Application for a non-material amendment following a grant of planning permission. Town and Country Planning Act 1990

REPLACEMENT OF EXISTING STUDIO BUILDING, ADJACENT TO HOUSE, WITH NEW STUDIO BUILDING, TO BE USED AS AN EXTENSION TO HOUSE. THIS APPLICATION MAY AFFECT THE SETTING OF A LISTED BUILDING.

K/9/19/HH

GA - Proposed Elevations looking East 1 & looking West

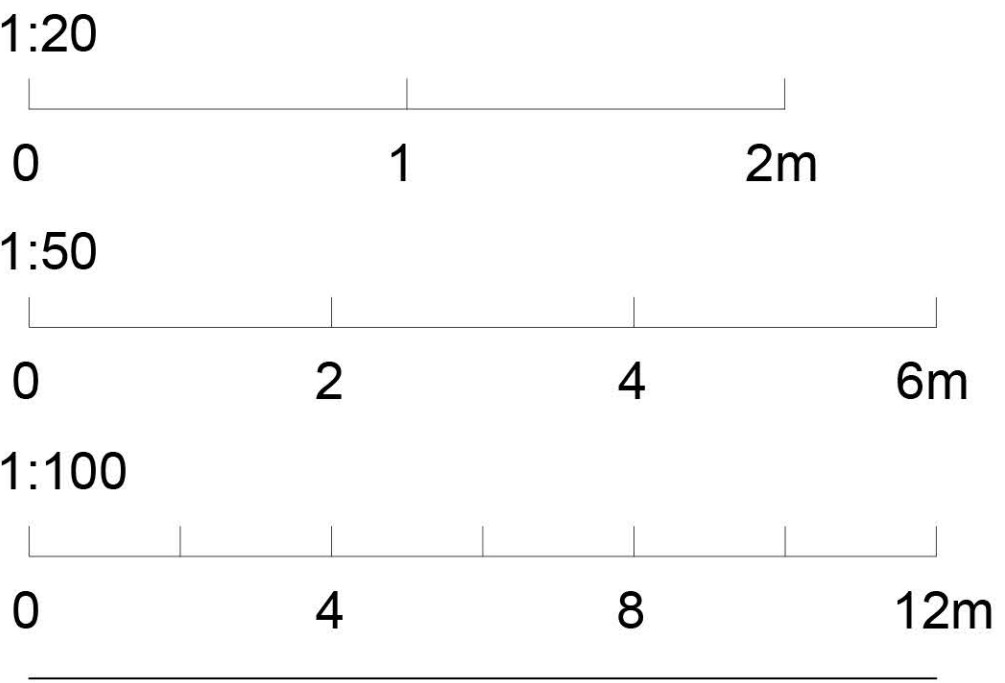
We would like to raise the floor of the building by 30 cm. In addition, and to mitigate any perceived impact on our neighbors, we would propose to move the location of the building 1 meter further away from the southern boundary hedge and towards the main building in Kingston Corner. The proportions of the building will not change.

This would put the elevation of the western end of the building 5.8m above ground instead of 5.5m. We note that this is still below the planned roofline of the recently approved garage extension of our direct neighbor (K/5/20/HH). The garage extension approved in K/5/20/HH sits directly on the road, forward of their and our buildings on the highest part of land in the plot and thus has greater visibility from the road.

KC_PLANNING-AA1100.01 - Site Plan A3
KC_PLANNING-AA1400.01 - GA Elevations
